**Planning Department
Transportation Development Services**

Re: 4th & Montano Dental Office
5508 4th St., NW
Traffic Circulation Layout
Engineer's/Architect's Stamp dated 6-2-15 (F14-D055)

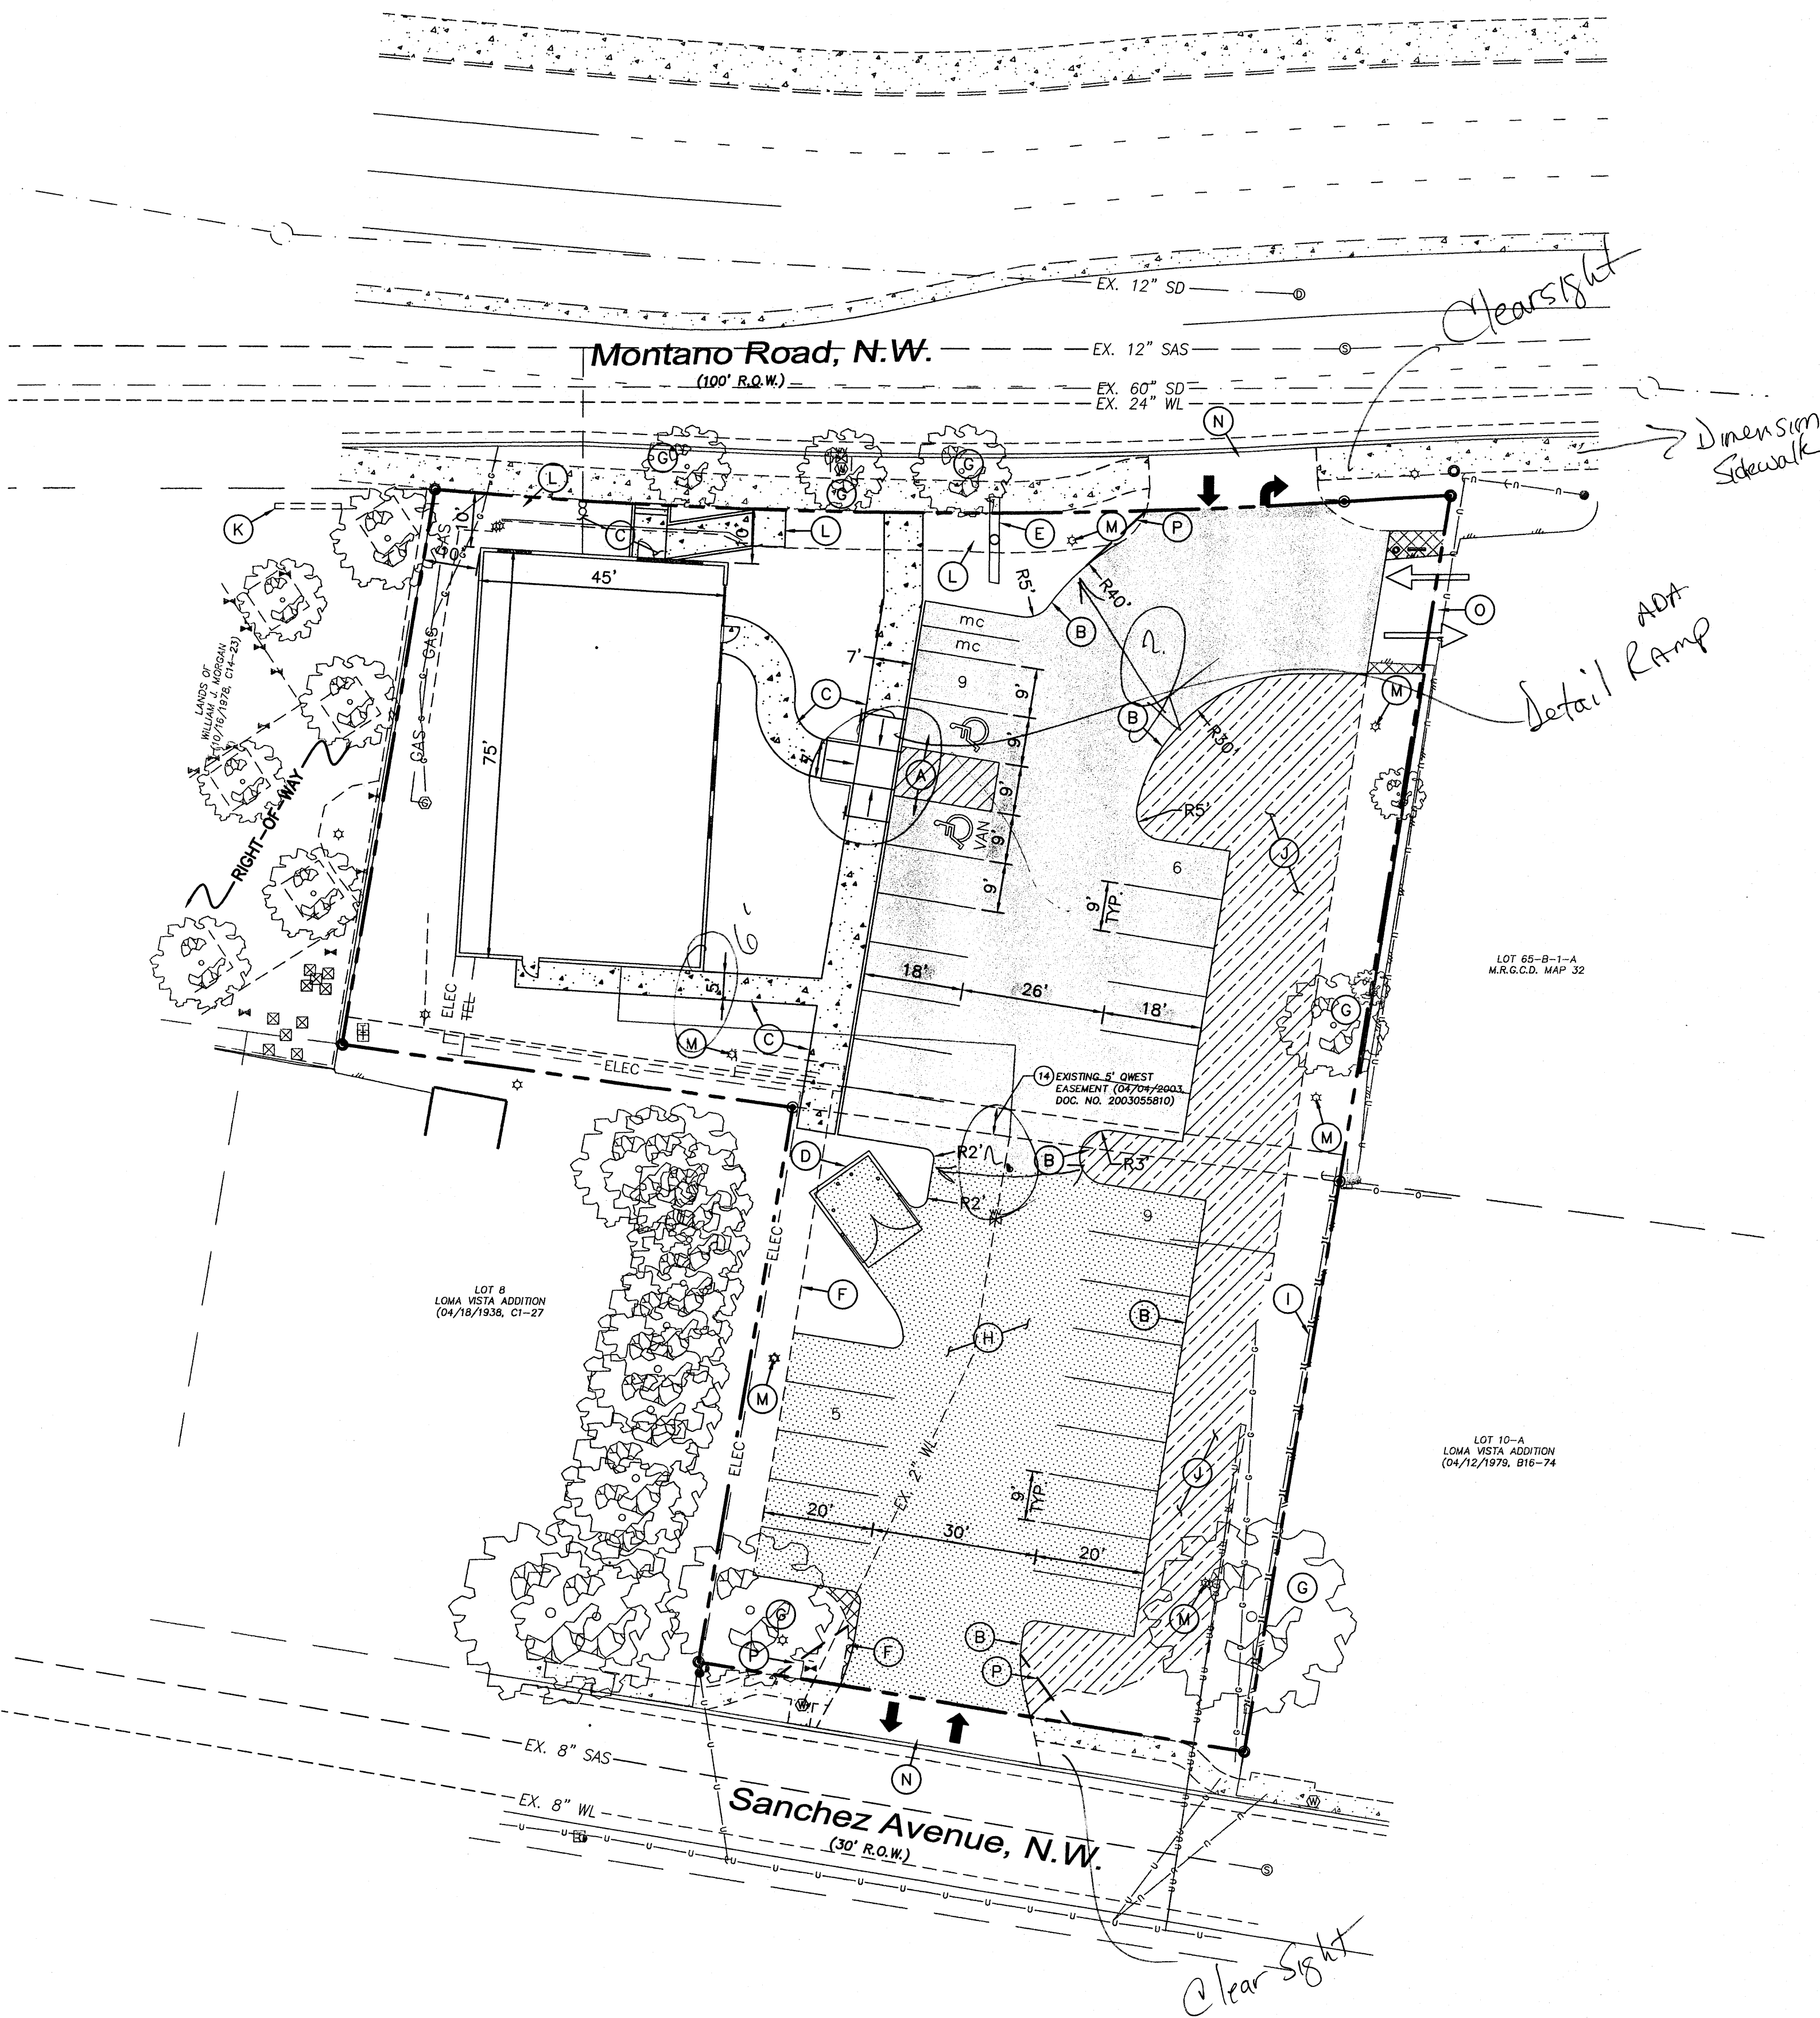
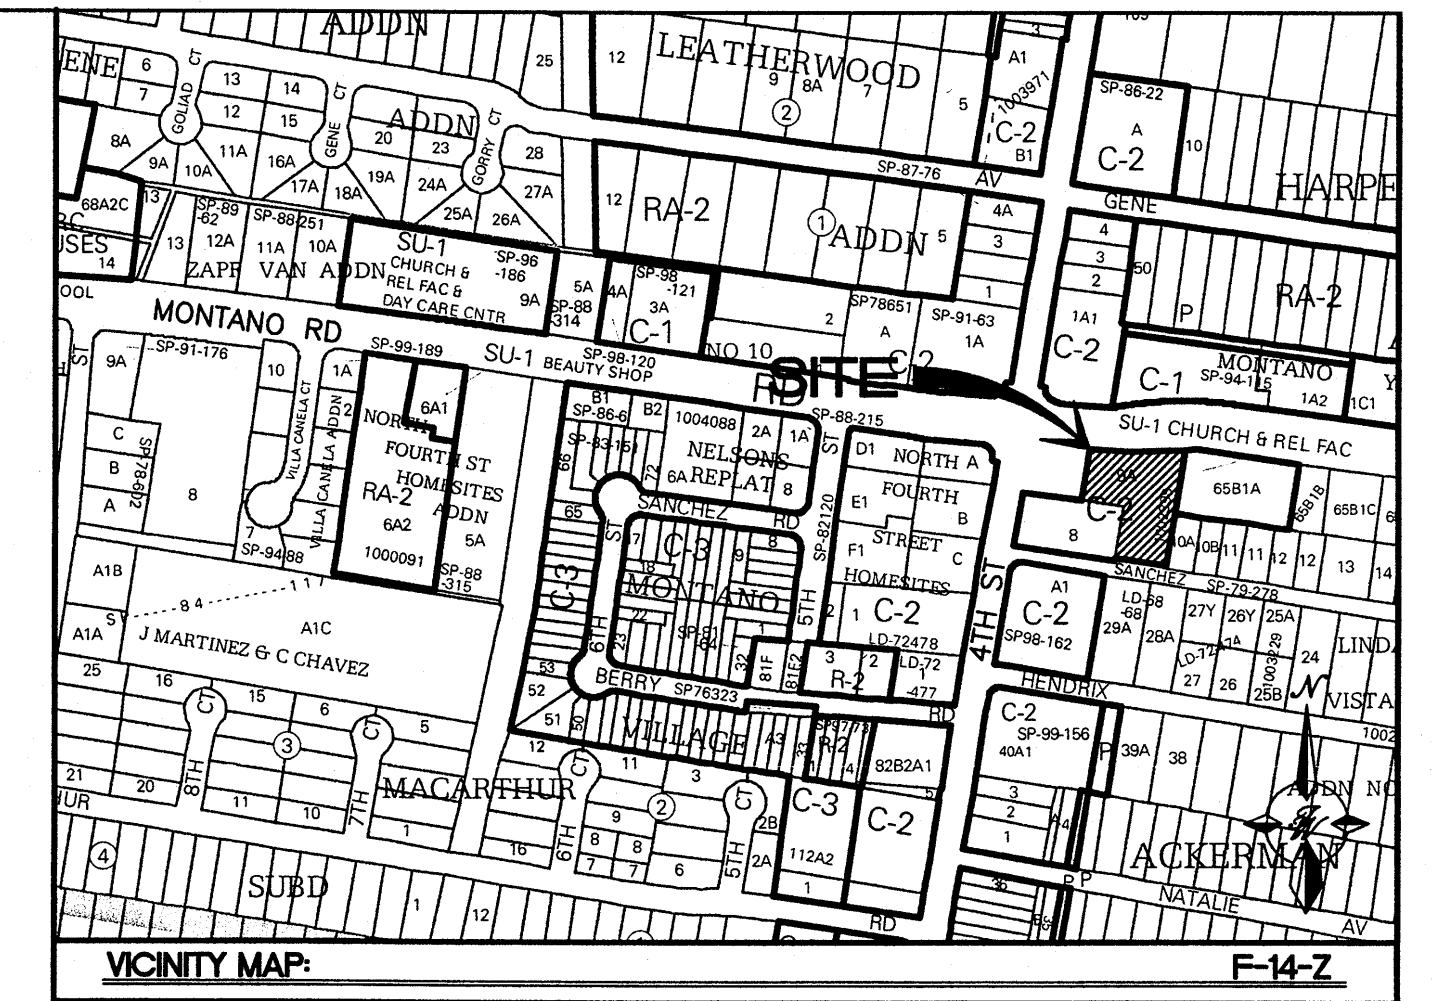
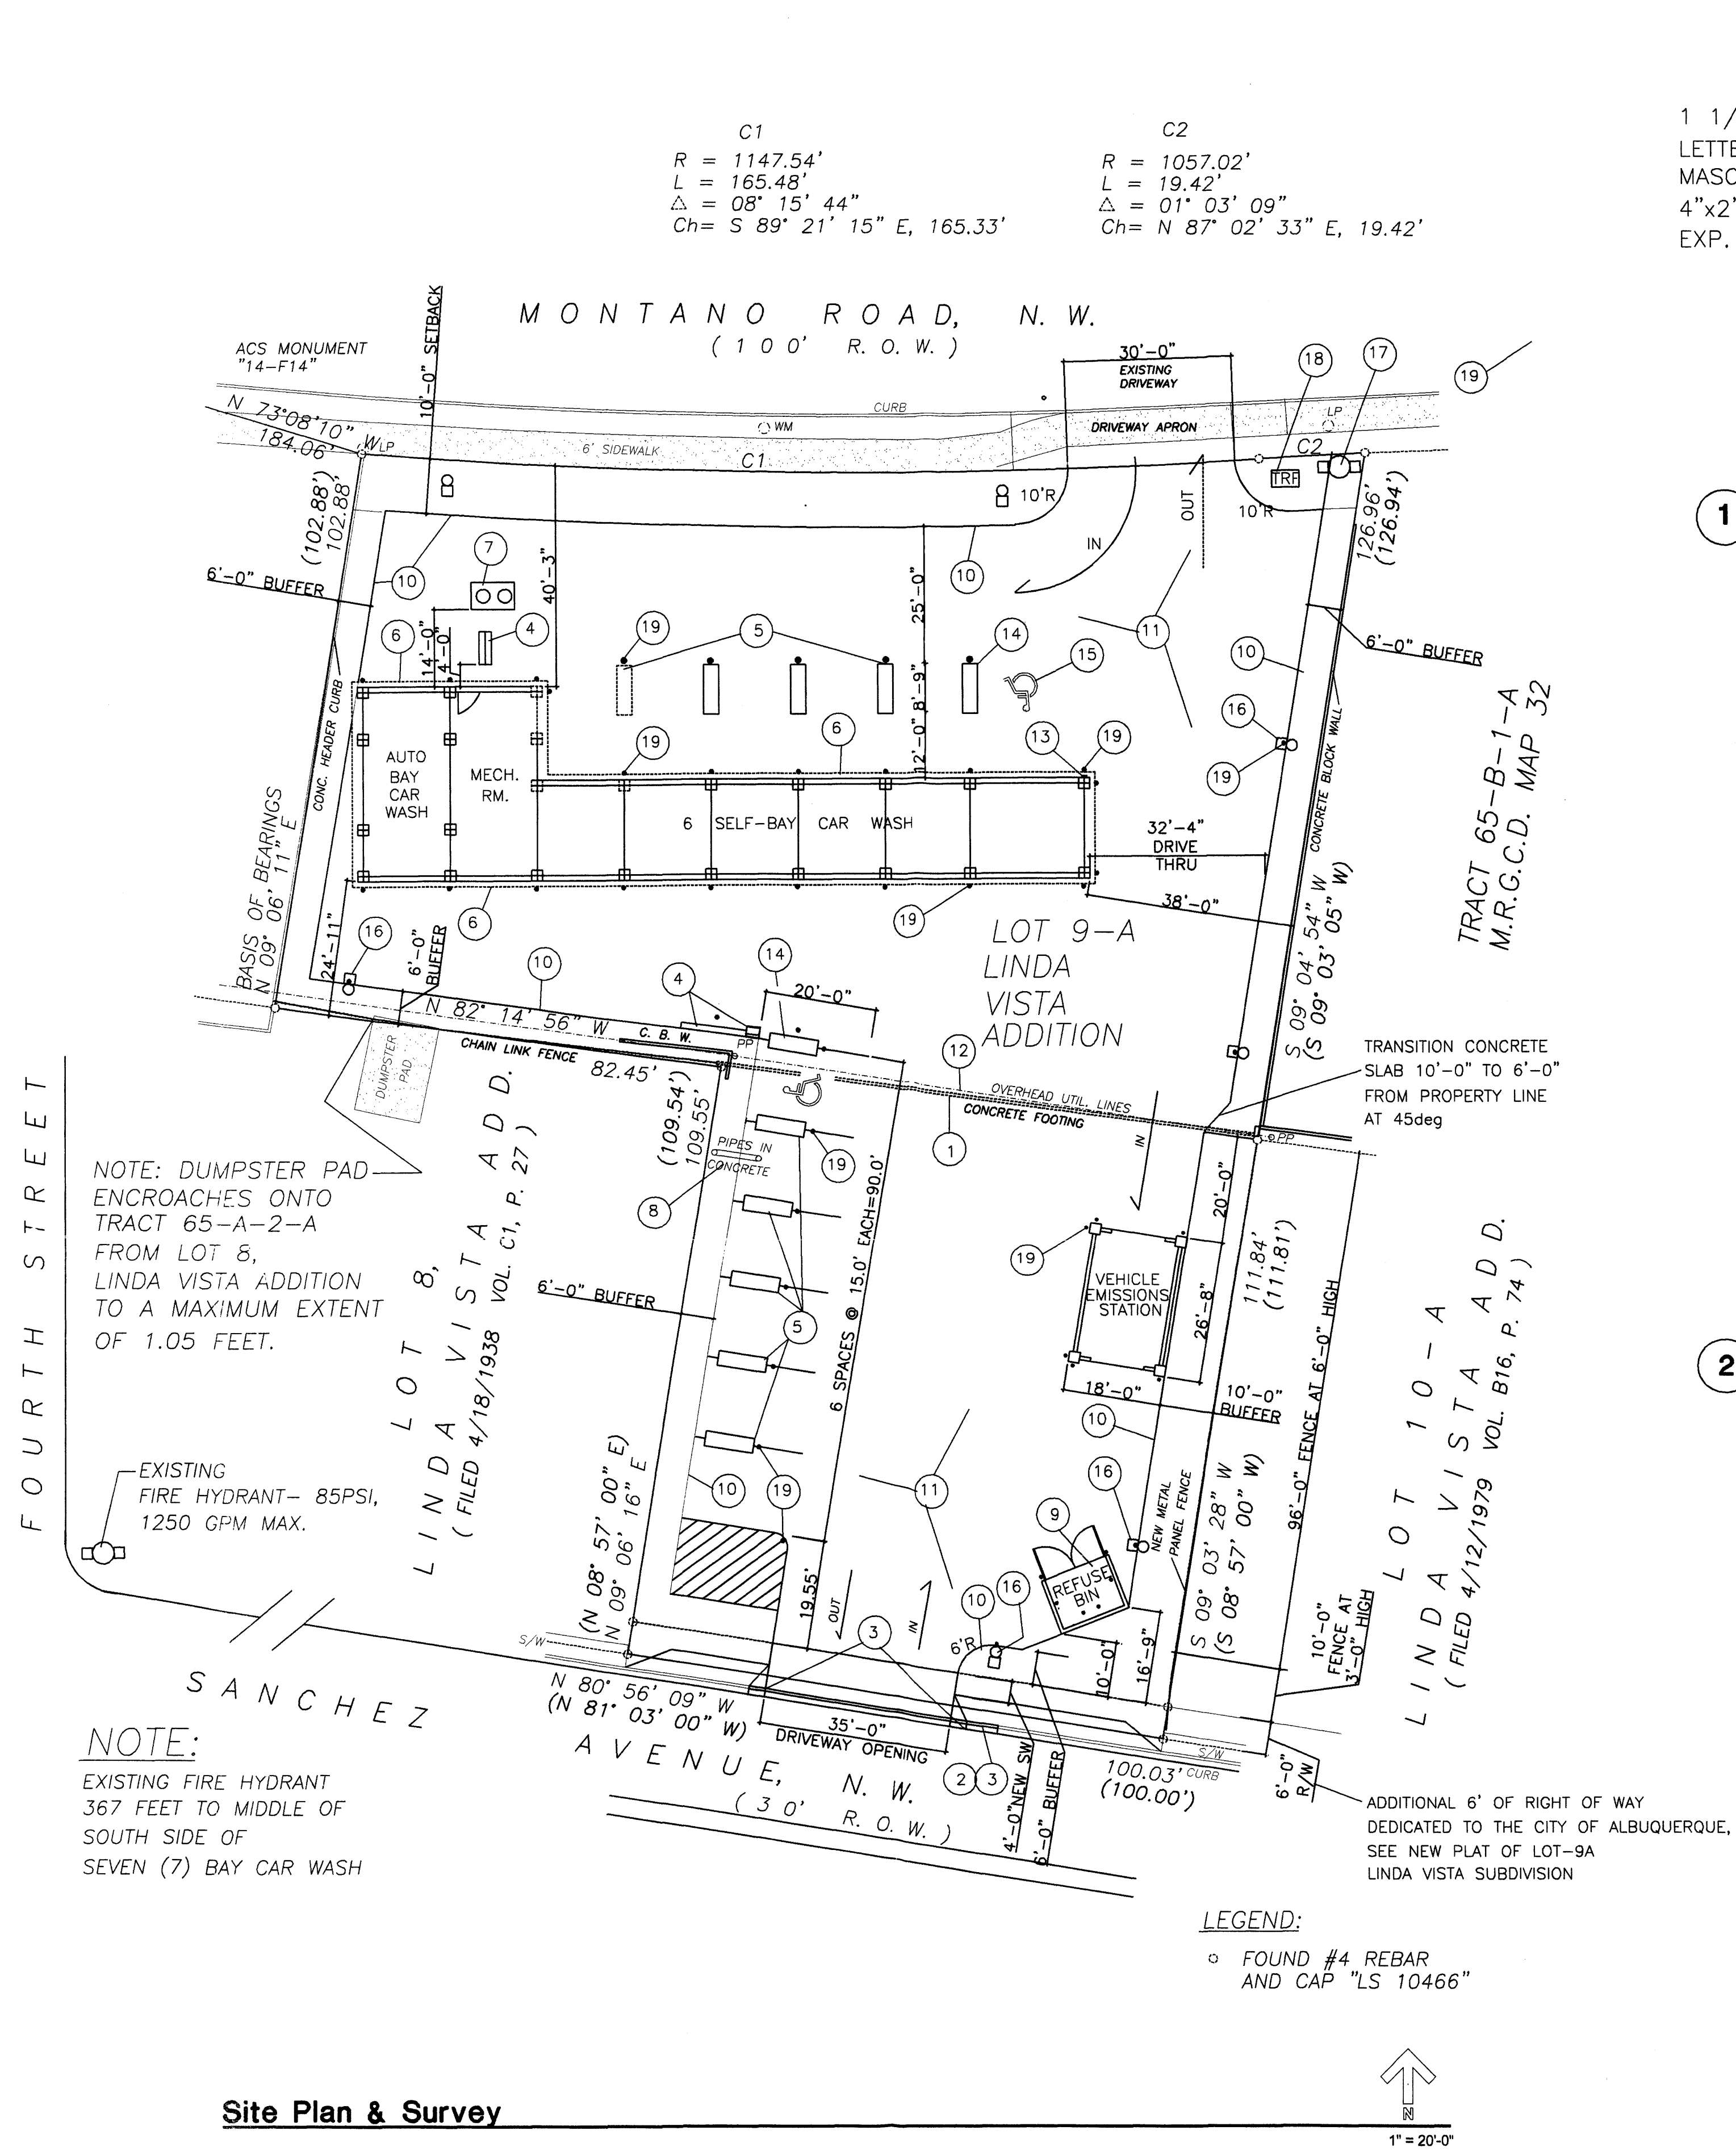
1. Clarify the extents of the current phase.
2. Identify all existing access easements and rights of way with dimensions.
3. Identify and dimension the existing right of way width, medians, sidewalks and curb cuts on Montano Rd., Sanchez Ave. and into the parcel to the east of the proposed building.

4. Please show a detail with dimensions and slope of the ADA pedestrian walkway transition from the ADA parking spaces.
5. The ADA van accessible sign must have the required language per 66-7-352.4C NMSA 1978 **"Violators Are Subject to a Fine and/or Towing."** Please show a detail of this signage.

6. The ADA access aisle shall have the words **"NO PARKING"** in capital letters, each of which shall be at least one foot high and at least two inches wide, placed at the rear of the parking space so as to be close to where an adjacent vehicle's rear tire would be placed. (66-1-4.1.B NMSA 1978)

7. Show all drive aisle widths and radii.
8. Design delivery vehicle route needs to be shown.
9. Please provide a sight distance exhibit (see the *Development Process Manual, Chapter 23, Section 3, Part D.5 Intersection Sight Distance*). Please provide this detail at the Montano Rd. and Sanchez Ave. entrances.

10. Please add the following note to the clear sight triangle: "Landscaping and signage will not interfere with clear sight requirements. Therefore, signs, walls, trees, and shrubbery between 3 and 8 feet tall (as measured from the gutter pan) will not be acceptable in this area."
11. Please include a copy of your shared access agreement with the adjacent property owner to the east of the proposed building.
12. Work within the public right of way requires a work order with DRC approved plans.
13. Please include two copies of the traffic circulation layout at the next submittal.
